Bonham's Field, Main Road, Yapton

Planning Reference Y/63/19/RES

Approval of reserved matters following grant of Y/1/17/OUT (access, appearance, landscaping, layout and scale)

Yapton Parish Council (YPC) has given careful consideration to the above application outlining the detail of the 56 dwellings at Bonham's Field, Yapton.

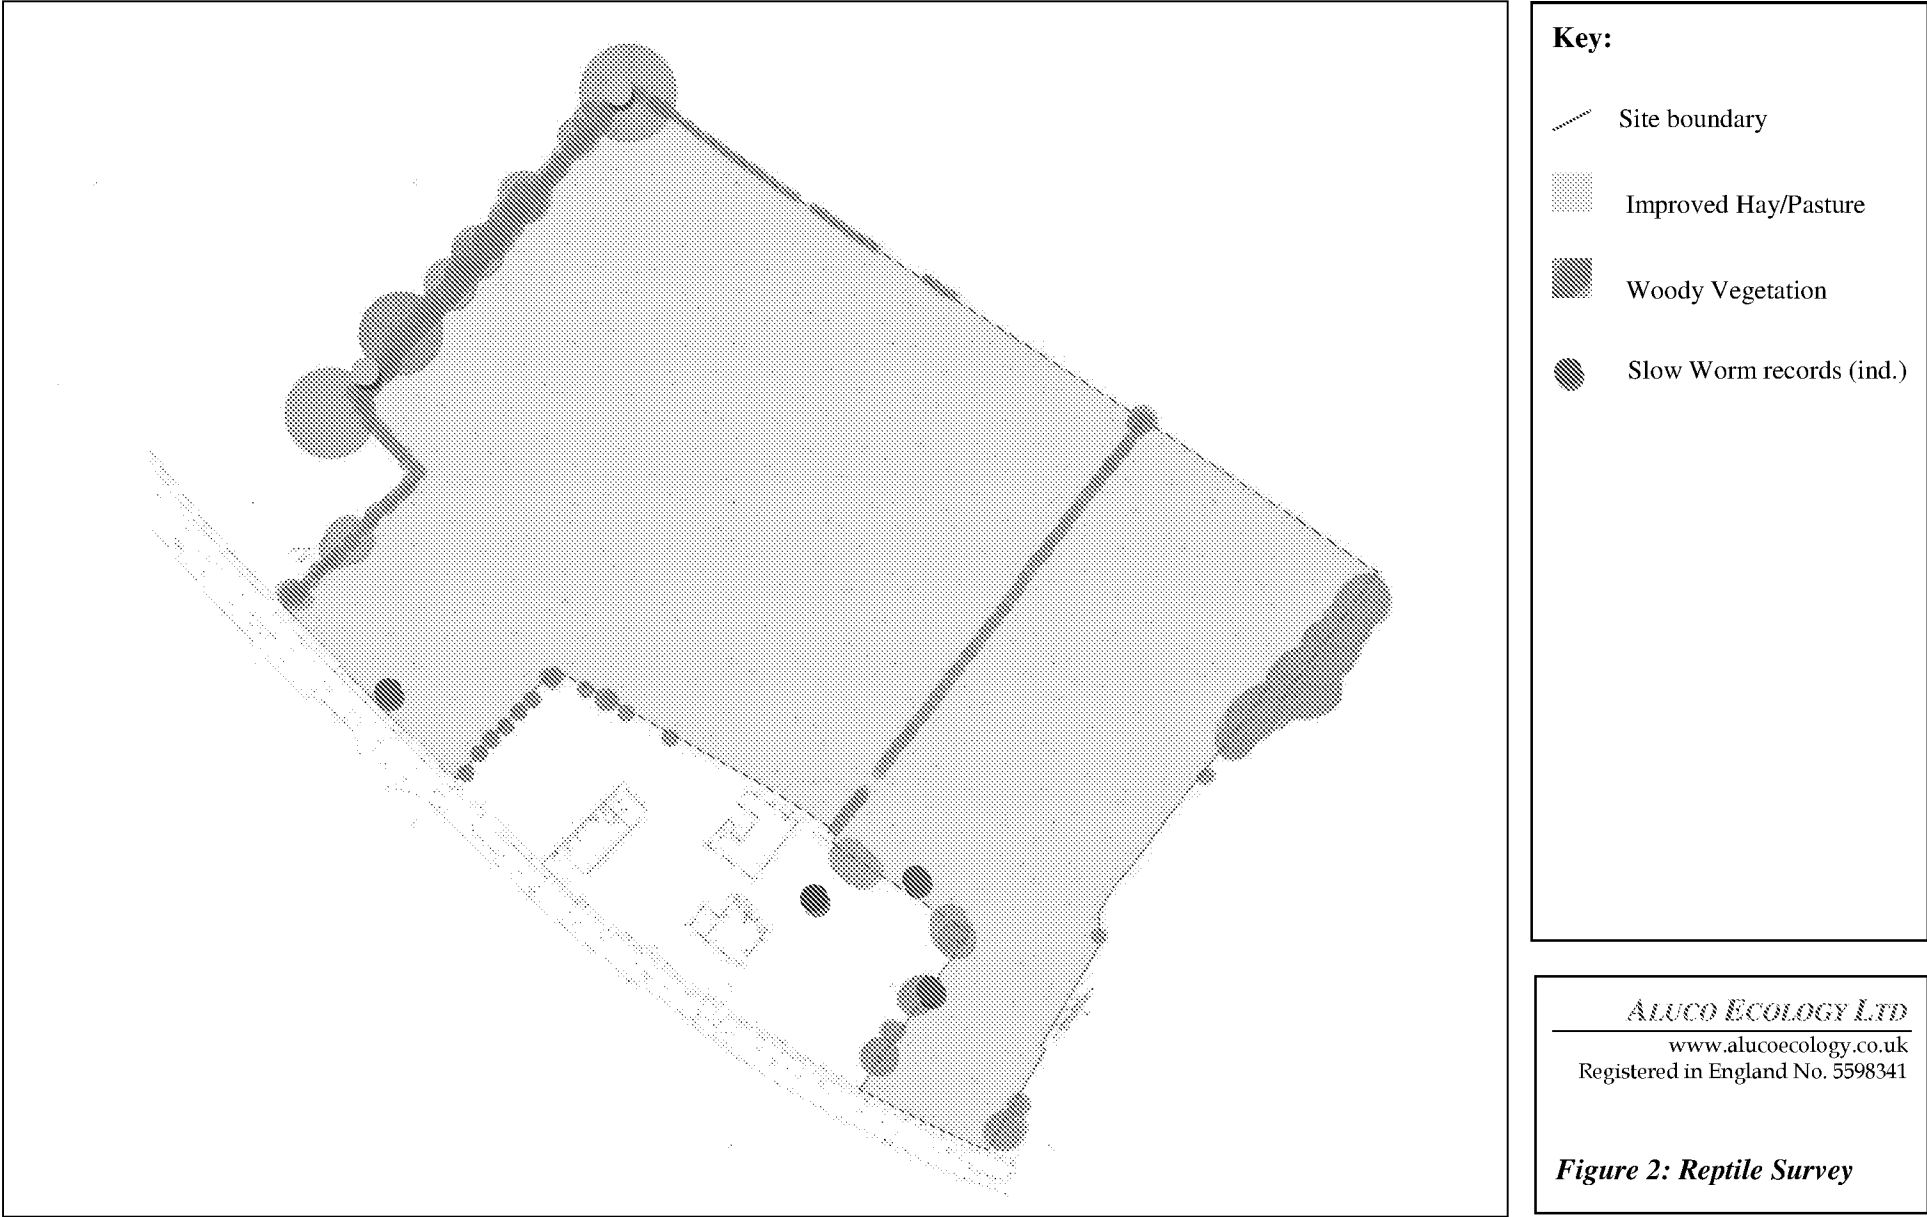
Parking. YPC note that parking standards have been met but are dependent upon designated garages remaining as such. YPC require that a restriction is placed on converting garages to ancillary living accommodation for the first 10 years from the final occupation of the scheme. This will enable the scheme to grow into its intended form and avoid unnecessary and unintended stresses placed on its streetscape, open space and accessibility through displaced parking resulting from loss of provided garage space.

YPC would also seek that the central core of parking within the site is softened by the use of CORE Grass or similar green permeable parking system. This would maintain the practicality of hard landscaping for parking areas but provide a softer finish providing a more rural outlook onto green space opposed to tarmac/block paving.

It would seem that the applicant has simply looked at the site in isolation and ignored the future potential for complete accessibility in this area. YPC would therefore request that a condition is specified outlining the need for suitable gaps along the northern boundary for the implementation of future green routes when landownership allows.

YPC note and welcome that there is a proposal for a footpath through the orchard area and southern landscaping. YPC require a condition that will specify the Bonhams Field, Main Road, Yapton
Planning Reference Y/63/19/RES
Approval of reserved matters (access, appearance, landscaping, layout and scale)

proposed path is a public right of way for multi-user use and fully DDA compliant, built to an appropriate specification for immediate use after the first occupation of the scheme. Landscaping of the path must reflect that of a former meadow/field with sufficient buffers/margins to ensure good biodiversity along the improved public multi-user pathway. This would help enrich the local environment and enhance Yapton's rural backdrop and setting of the surrounding listed buildings.

YPC note the density of 56 units is generous. However, YPC would expect a scheme with such generous spacing to reflect careful distribution of housing type and sensitive placing of units within various street-scenes notably those facing the rear elevations of listed buildings Bonhams Barn and Bonhams (plots 30-41).

YPC appreciate that the housing faces outwards but would seek a more varied site line from street level for plots 36-41 or alternatively the units to better relate to the heritage of the two facing listed buildings in terms of overall design.

Figure 3 – Open Space Landscape Strategy: Terra Firma 2019 (with annotations)

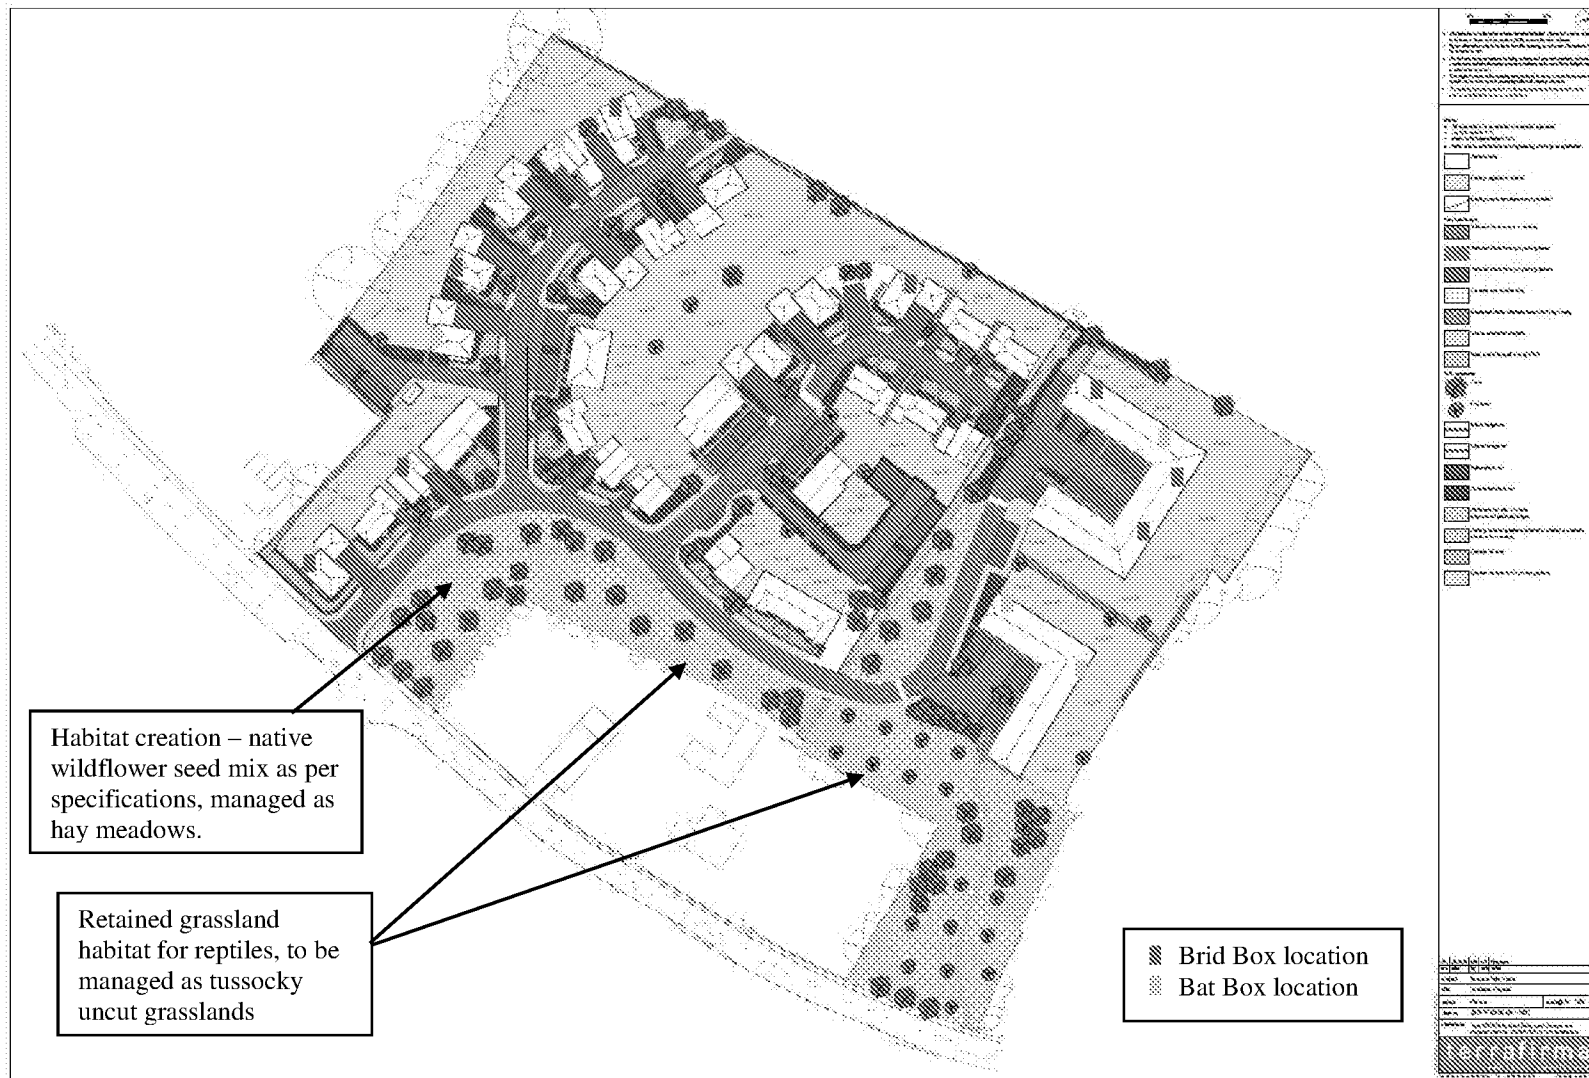
YPC welcome the proposed orchard and landscaped areas and would request that the orchard use Sussex heritage fruit trees. YPC would also ask that the area designated as a play area has interesting landforms and structures created within it to encourage an imaginative play area and enhance wellbeing.

YPC expect the designated landscaping margins to be maximised in depth and use of planting to encourage a biodiversity, wildlife and blend into the rural backdrop of the site.

YPC seek a condition to ensure the proper management and maintenance of the Orchard area for a minimum of five years to ensure it becomes fully established as an orchard.
